PAINSHILL RESIDENT'S ASSOCIATION

M25 junction 10/A3 Wisley Interchange

January 27, 2020

**Reference M25 Junction 10/A3Wisley
Representation From Painshill Resident's Association Specific Hearing Action Note 15**

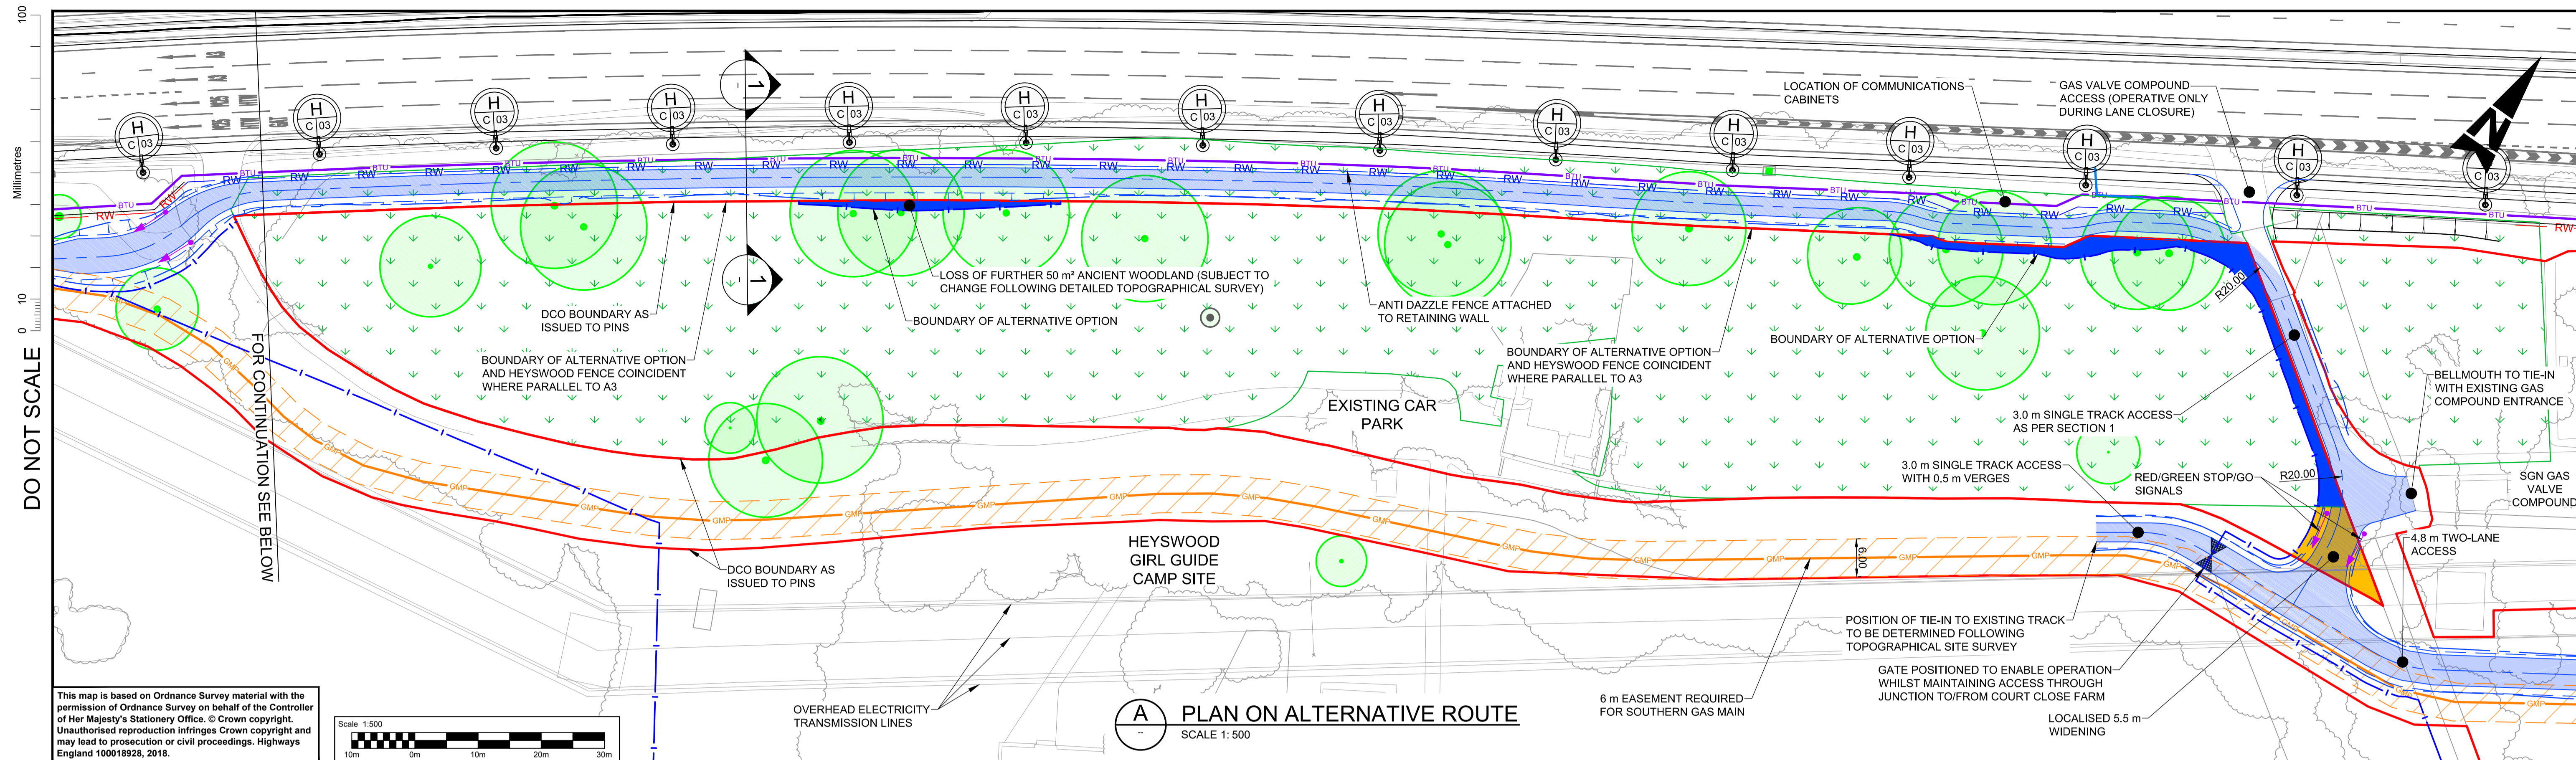
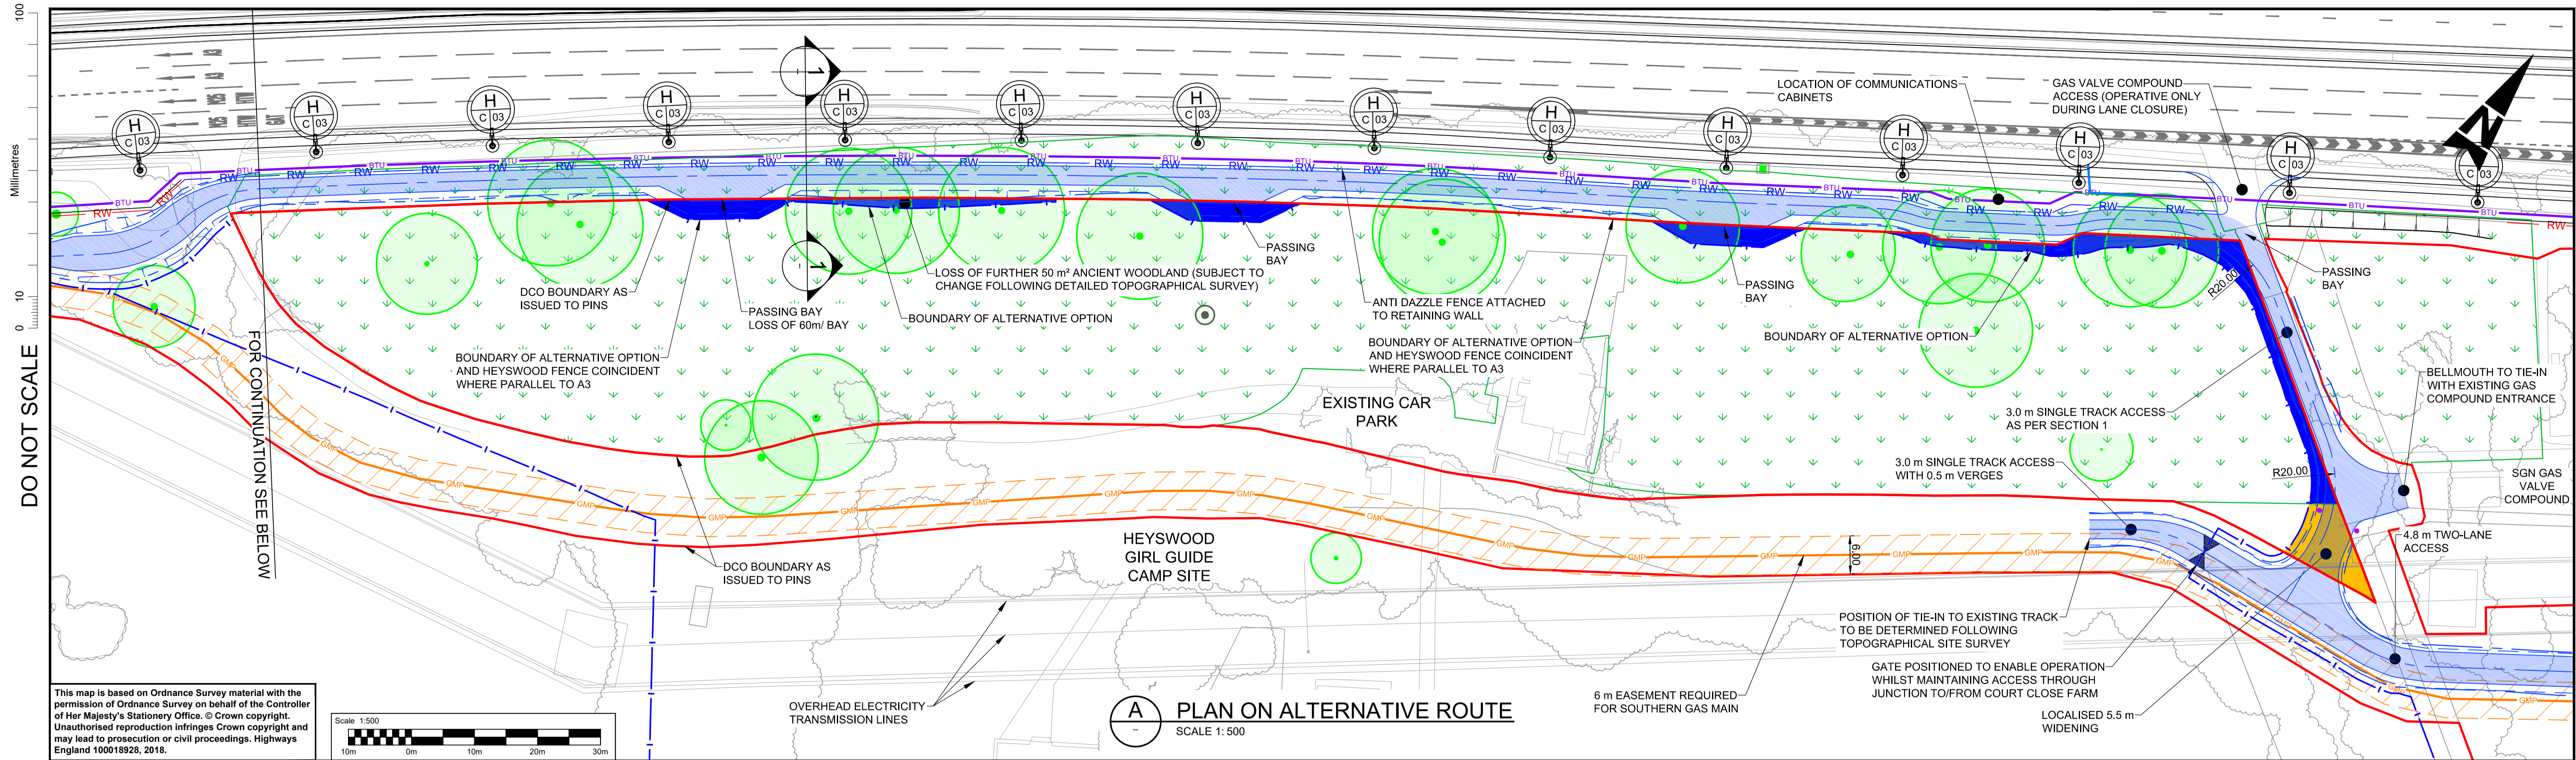
1. The siting of the service road Junction for Close Court Farm etc.

It is accepted that representation and consultation by Highways England regarding the amended A3 M25 Interchange was held with Painshill Residents Association during the initial stages of the development, where various options of the development and service road access points for the properties affected by the development were advised and explored. However with regard to the conceptual proposal currently before the Planning Inspectorate, Painshill Residents Association maintains that the new service road access point was neither discussed nor advised to us prior to its final submission to the Planning Inspectorate. It's disappointing that no such consultation took place since, had we been aware that the proposal had changed, we would not have supported it in its current form. We raised this point at our meeting and requested Highways England to shift the new service road junction on the A3 slip further down the slip road towards M25/ Junction 10. Alternatively to amalgamate this with a considered direct access to Close Court Farm, the Guides Association, Painshill Park Emergency Access, New Farm etc, due to its proximity to Painshill Roundabout.

Either suggestion would prevent the removal of carbon absorbing trees in the Christmas Tree Wood which limit noise levels, and provide biodiversity sustainability adjacent to Painshill Residents Association properties.

Highways England maintain that they alone cannot amend any detail at this stage, only on a directive from the Planning Inspectorate. We therefore look to you to consider all hazardous aspects of the siting of this junction, at its present indicated position, as advised under our previous correspondence and move this junction to a more suitable, less hazardous and less obstructive location.
